**RE: Paseo Marketplace
Conceptual Grading Plan
Stamp Date: 4/10/17
Hydrology File: D18D056**

**RE: Paseo Marketplace
Conceptual Grading Plan
Stamp Date: 3/2/17
Hydrology File: D18D056**

Attached is the revised Grading Plan for Paseo Marketplace. The following addresses the comments received on March 31st, 2016 regarding the submittal to the City of Albuquerque on March 3rd, 2016:

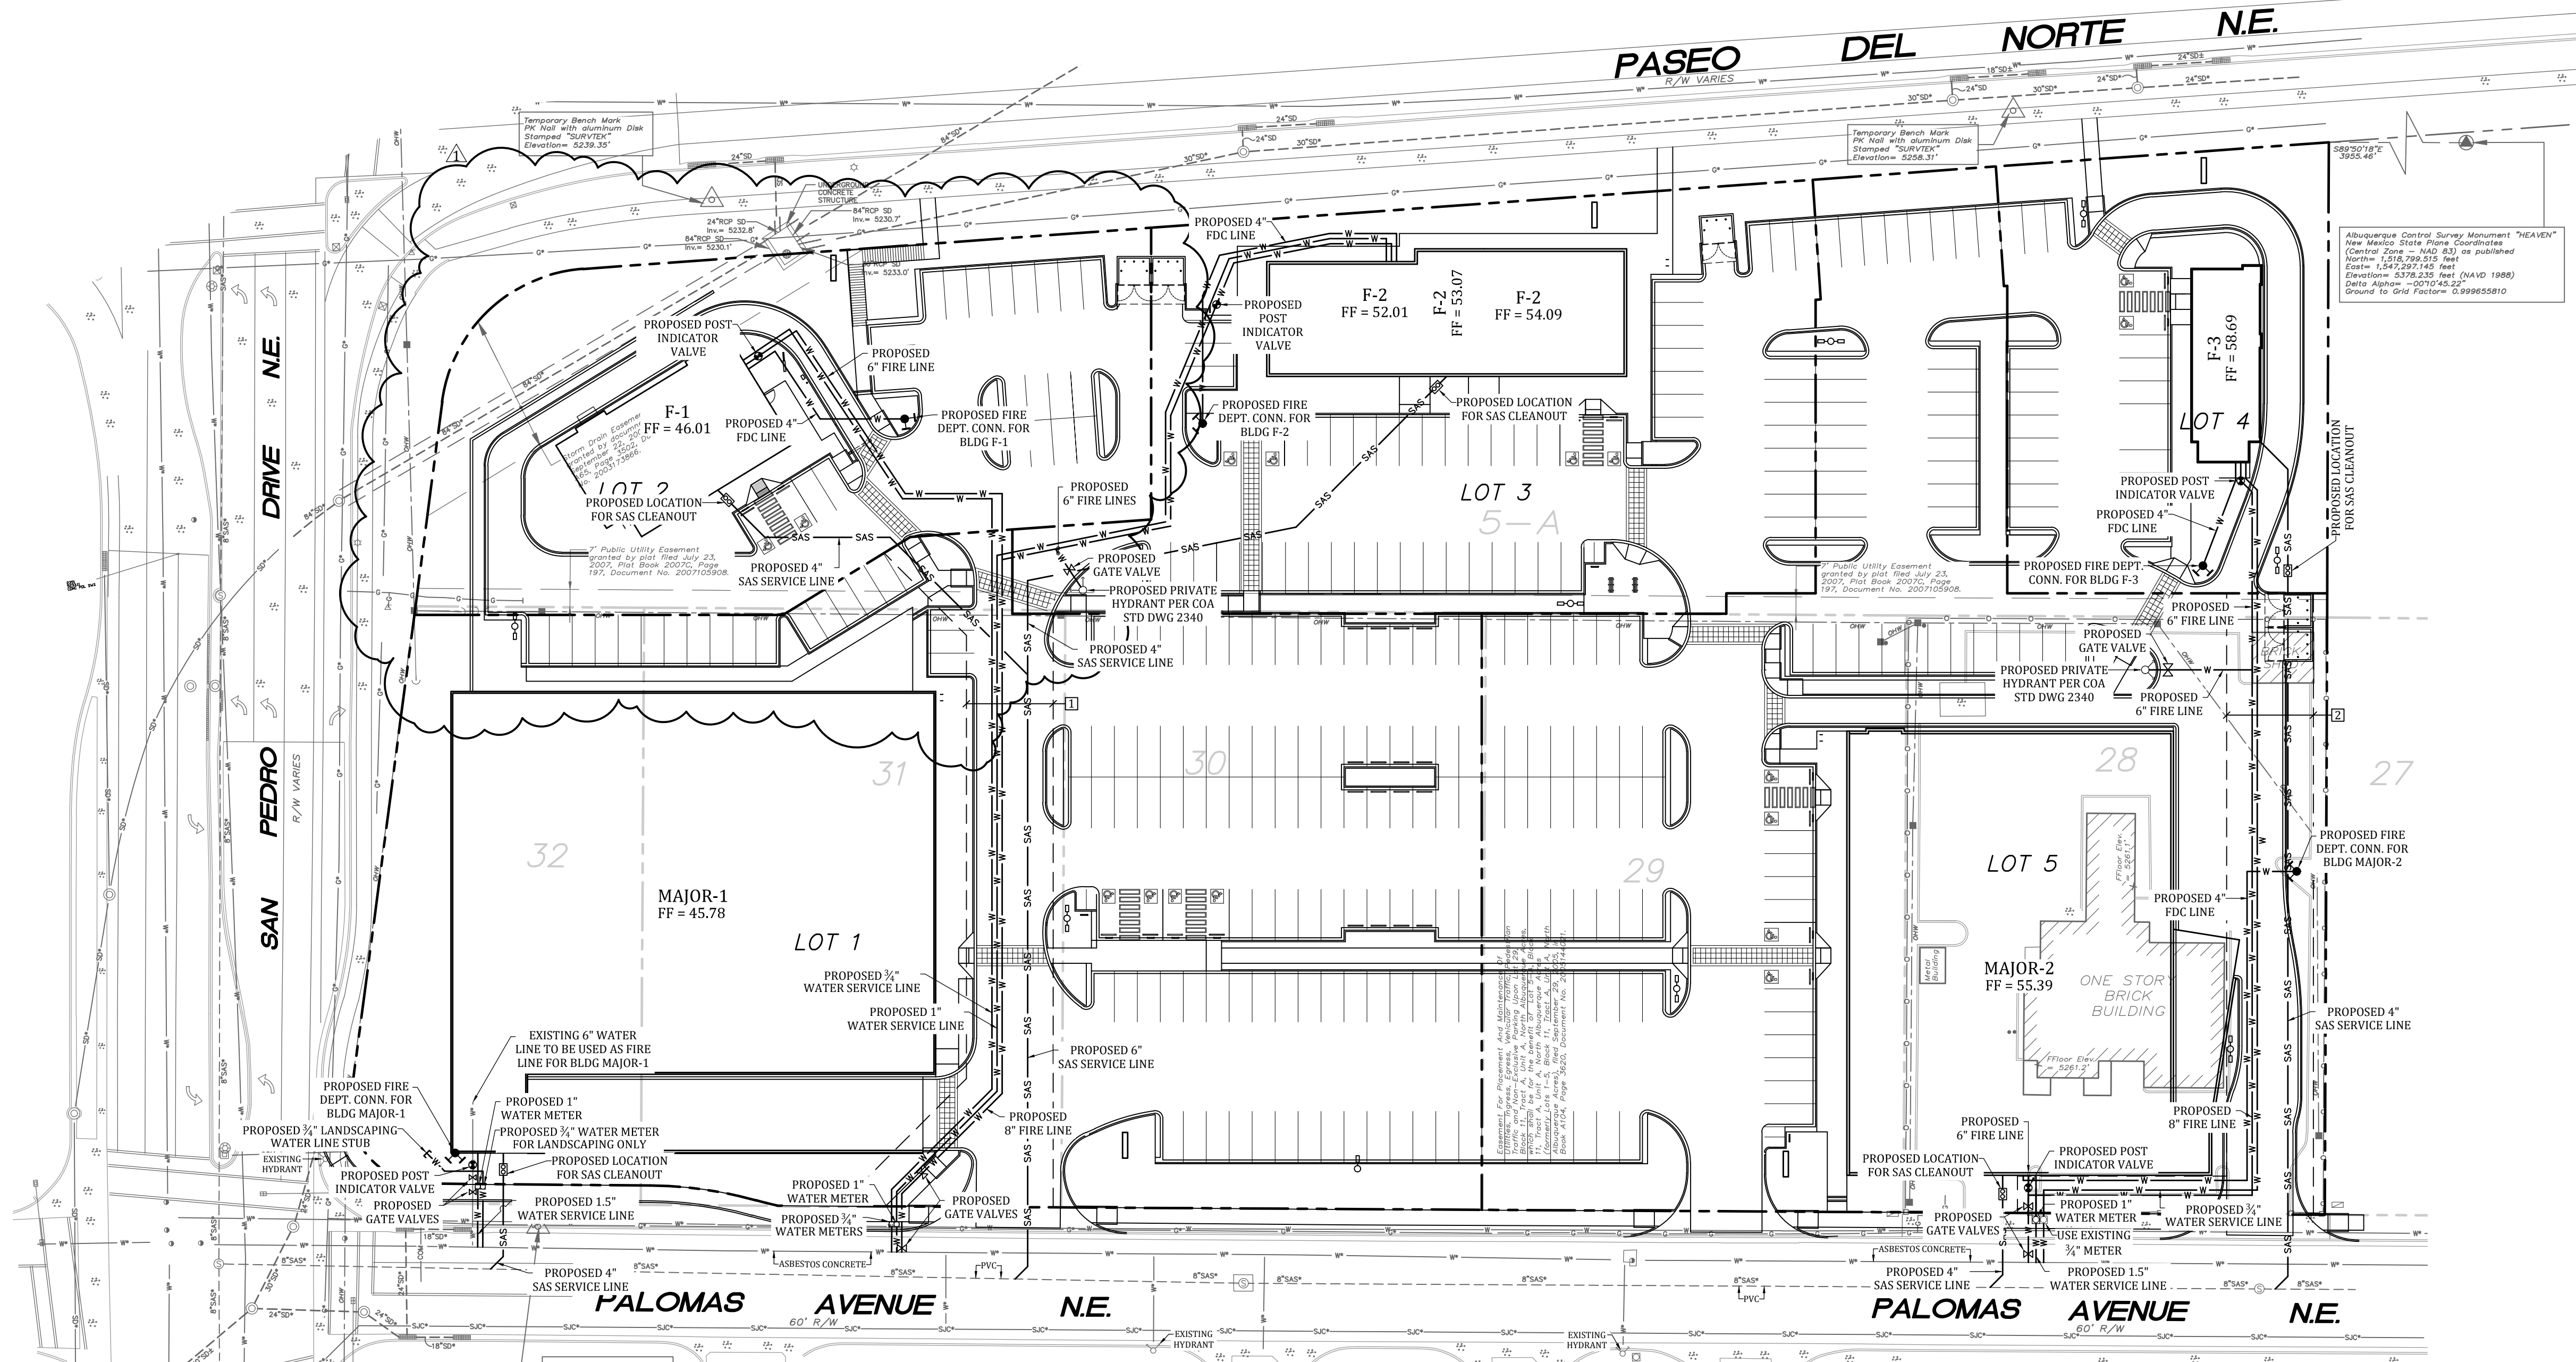
2. For your water quality pond for the subbasin 1, you are proposing a fire dept conn. for Bldg Major-2. Please shift this closer to the building and out of the water quality pond.

4. The proposed conditions section was a little hard to read. You might want to either add some space between the proposed subbasins or place all the information in a separate 8 ½ x 11 drainage report. This could also allow you to bring the site to a 1"=30' scale which would also make the Conceptual Grading Plan more readable as well.

5. For the proposed truck ramp, you call out a 4" NDS grate. I'm concerned about clogging of this inlet. Typically for a truck ramp, one places a French drain which can be easily cleaned out and if partially clogged, it will still function. You might want to take another look at this.

6. In Proposed subbasin 6, you have one building listed as Food. Just a reminder that for the drainage from the dumpster for this building will need to drain into the sanitary sewer.

The fire department connection has been relocated to the east side of Bldg Major-2. See updated plans.

The proposed conditions section has been separated into paragraphs for each subbasin. See updated plans. The scale remains a 1"=40' because the site development plan for building permit checklist requires that the Grading and Drainage Plan matches the scale on the Site Plan.

A trench drain has been added at the truck ramp for Bldg Major-2. See updated plans.

The dumpster area has been revised to drain into the sanitary sewer for the building. See updated plans.
